**HUNTER VALLEY OPERATIONS SOUTH MP 06\_0261 MOD 5  
RESPONSE TO SUBMISSIONS**

**ENVIRONMENT PROTECTION AUTHORITY – REVIEW OF RESPONSE TO SUBMISSIONS  
MP 06\_0261 MOD 5  
HV OPERATIONS PTY LTD**

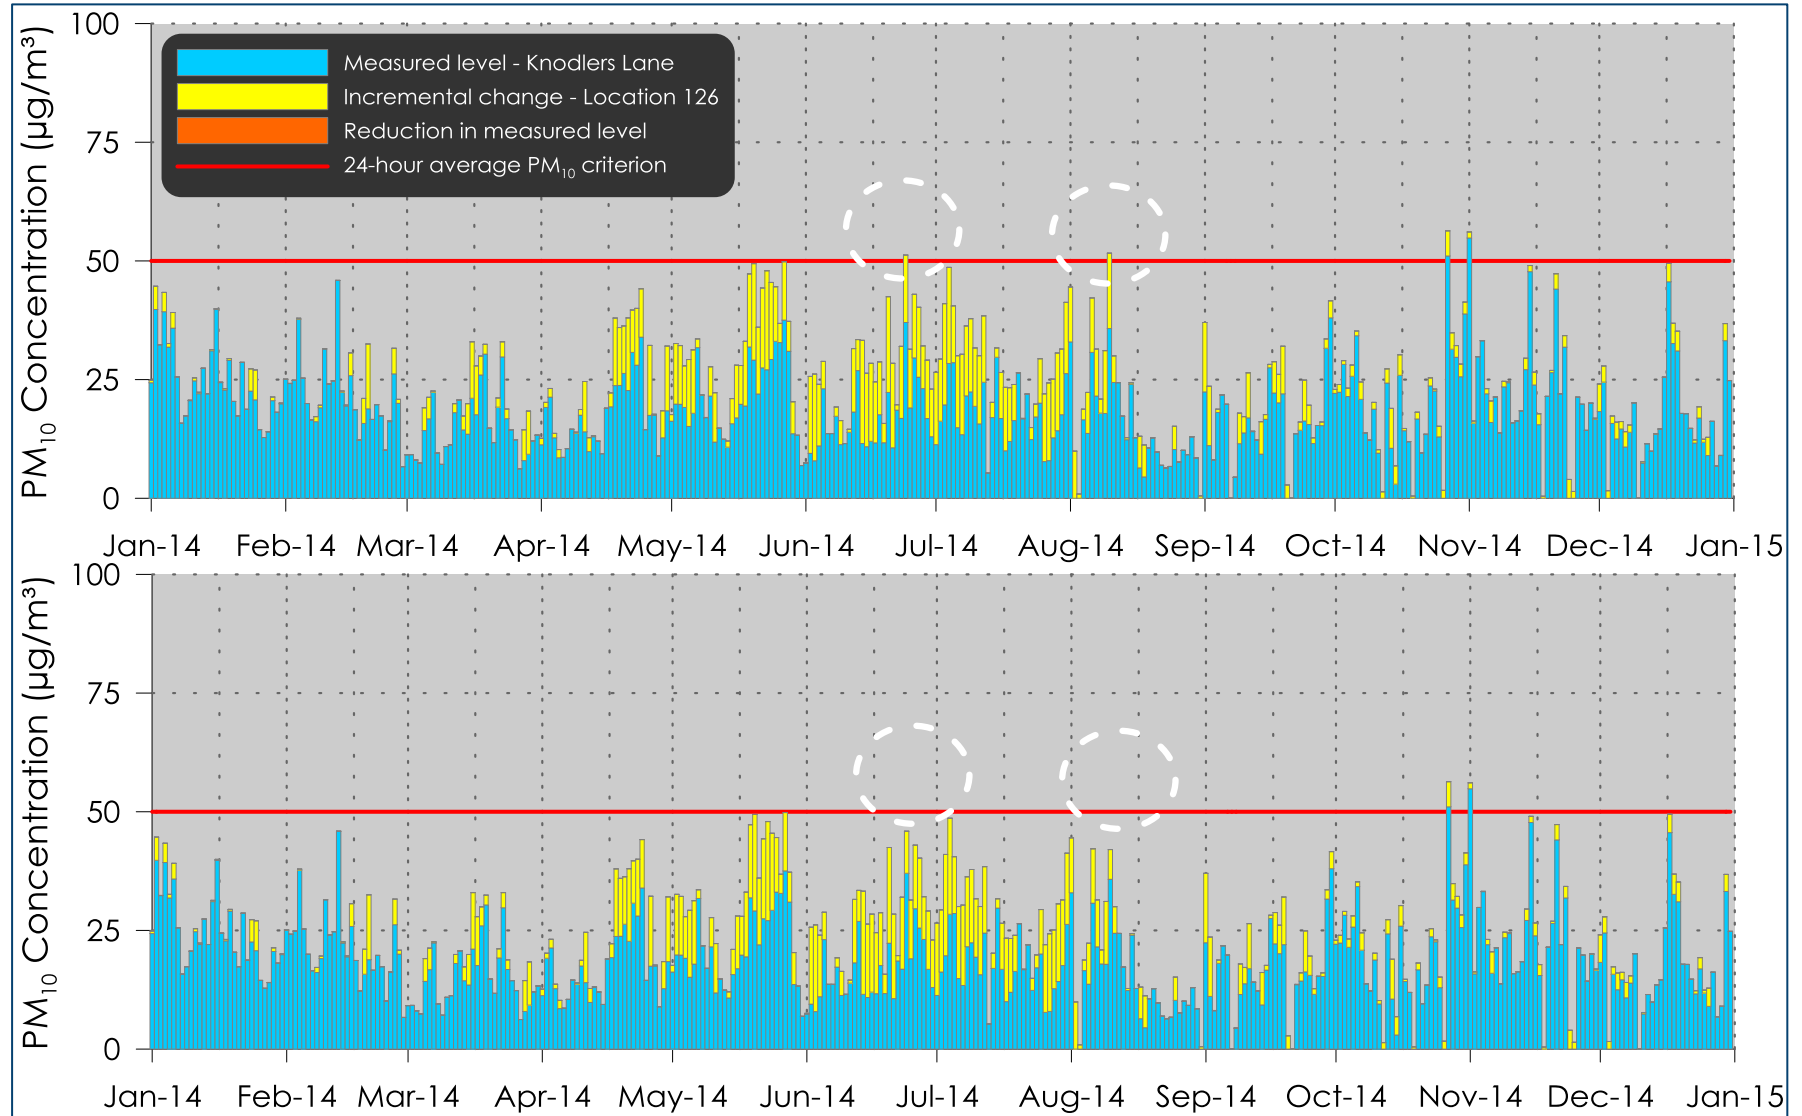
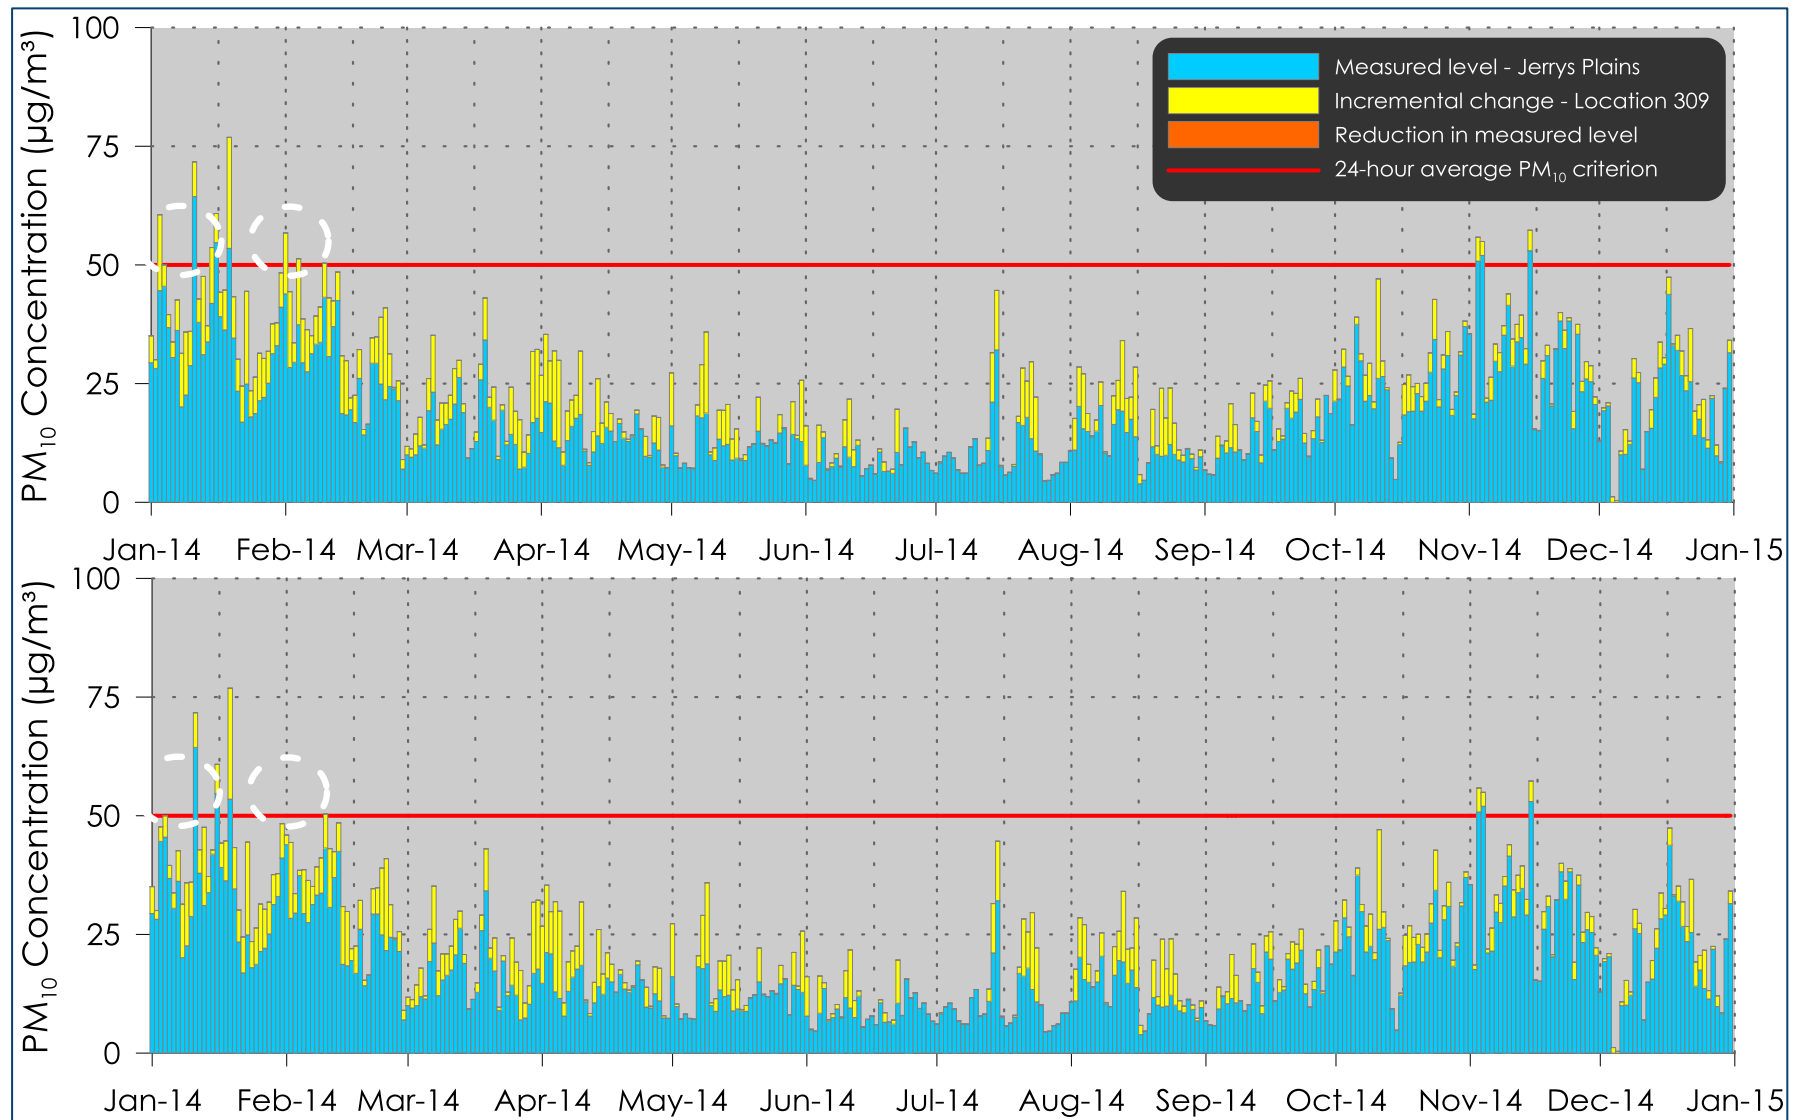
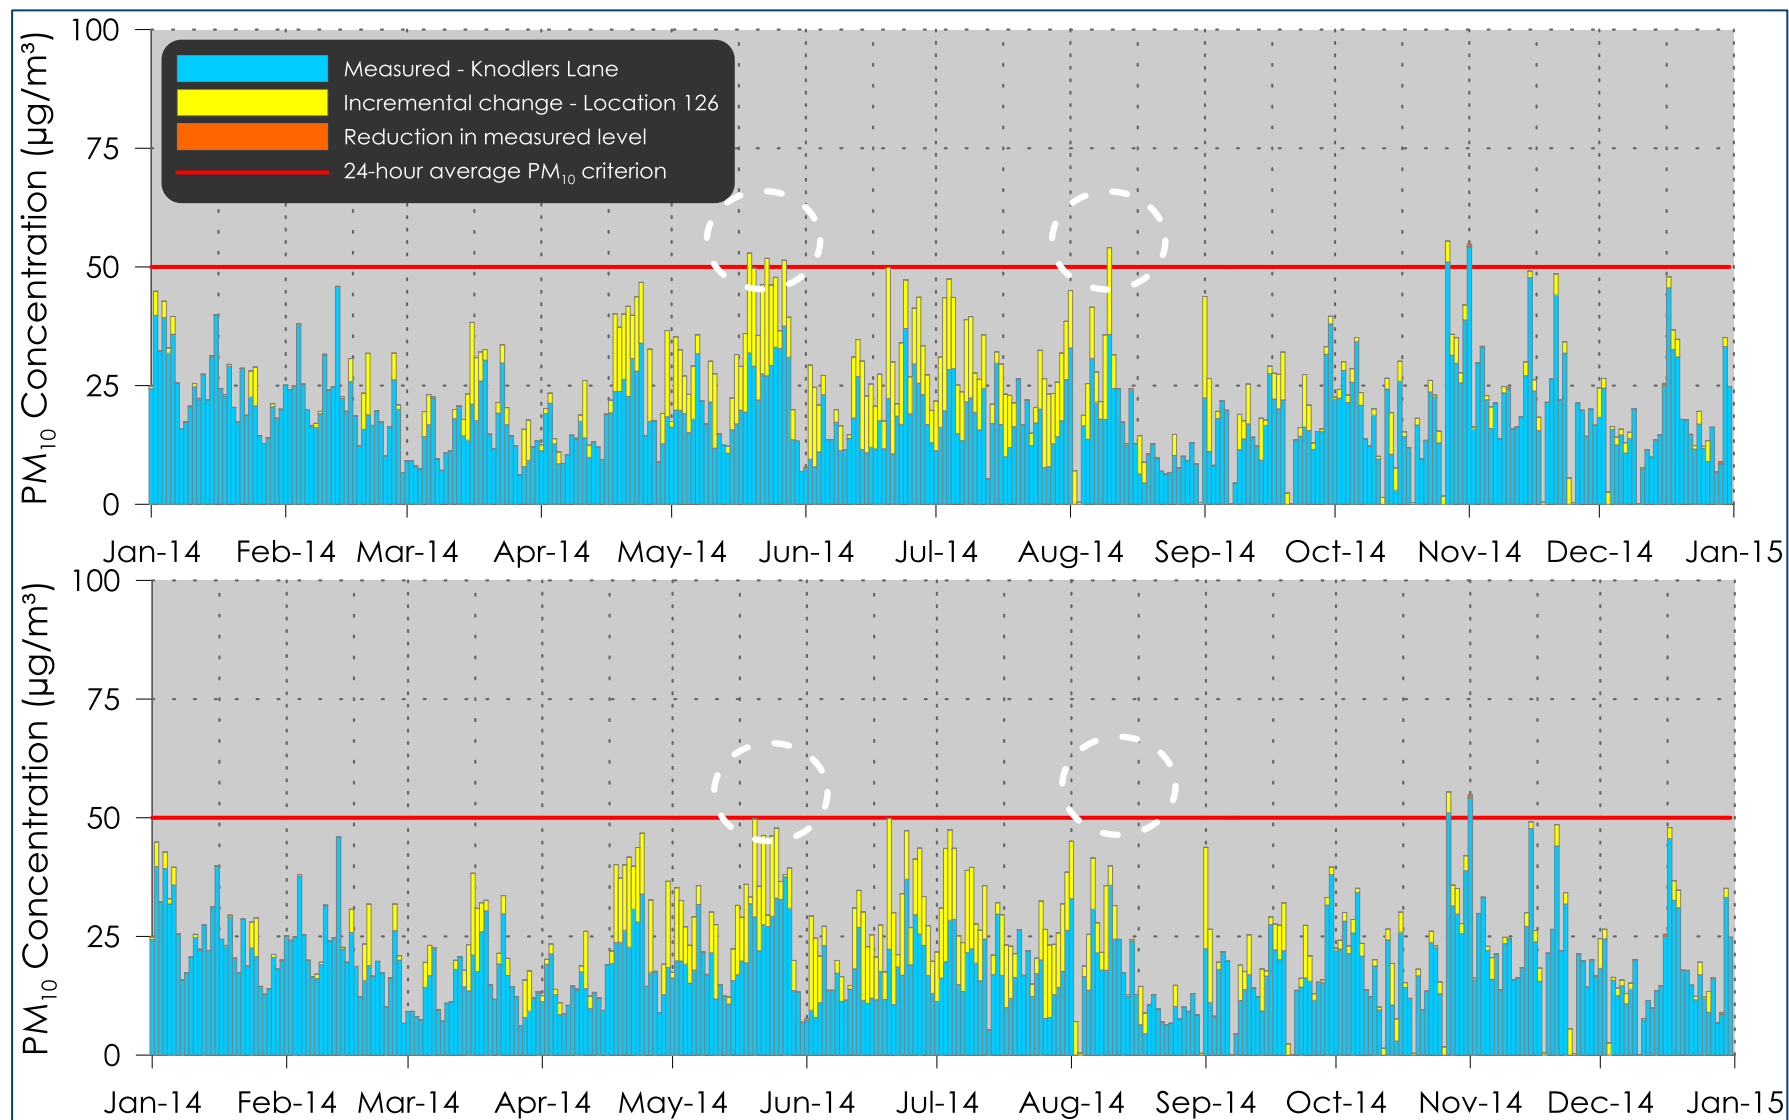
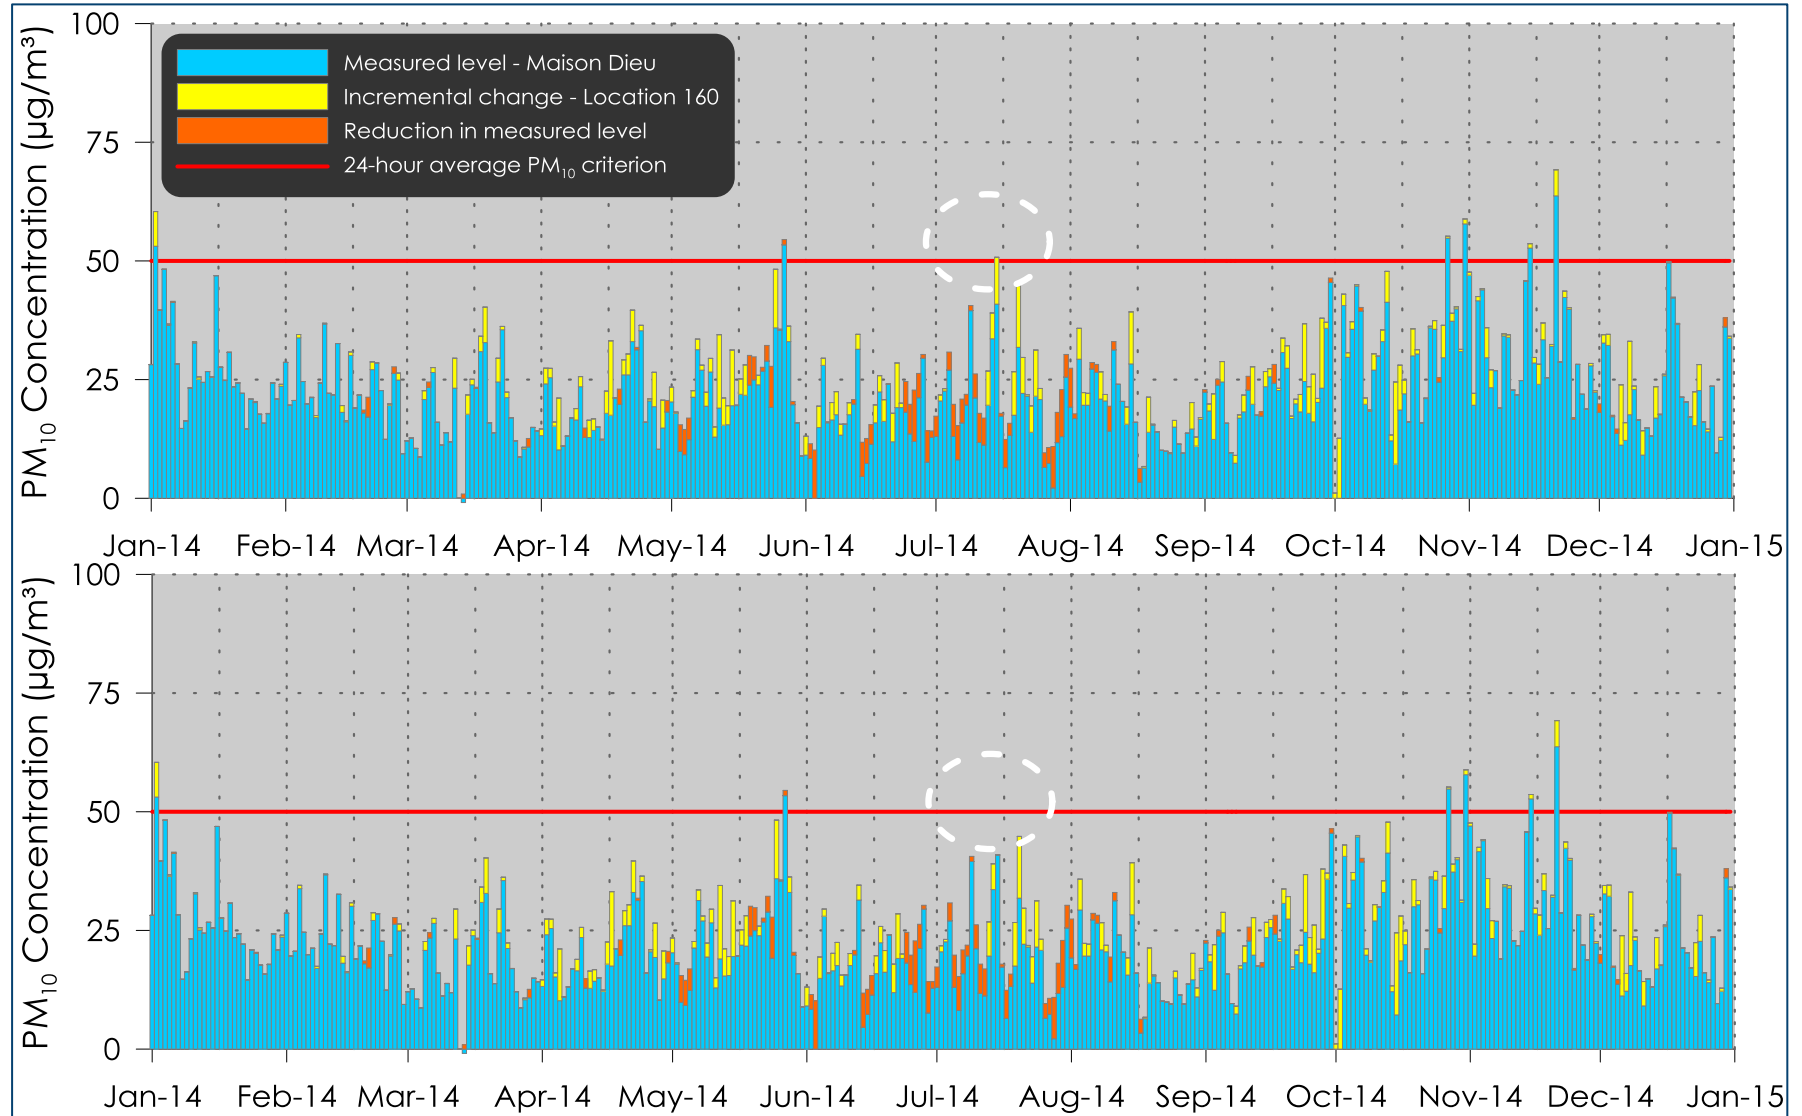
The RTS has stated the intended approach to mitigating the assessed additional exceedences of 24-hour impact assessment criteria. There is no analysis indicating the effectiveness of the planning and reactive management systems. In particular, there is no direct estimate of the ability of the system to mitigate the assessed additional exceedence days.

Section 7.7 of the Approved Methods Modelling requires that where impact assessment criteria are exceeded, additional mitigation measures must be assessed until compliance is achieved. To meet this requirement, evidence needs to be provided that the proposed management actions remove the additional exceedences of impact assessment criteria.

The EPA requires assessment showing that the proposed reactive management successfully identifies the additional exceedences and reduces emissions sufficiently that the exceedences do not occur.

It is clear that the real-time air quality management system is used. The performance of the system has not been shown. As set out above, to meet the requirements set out in section 7.7 of the Approved Methods Modelling, assessment is needed showing that operation of the reactive management system removes the additional exceedence days occurring without it.
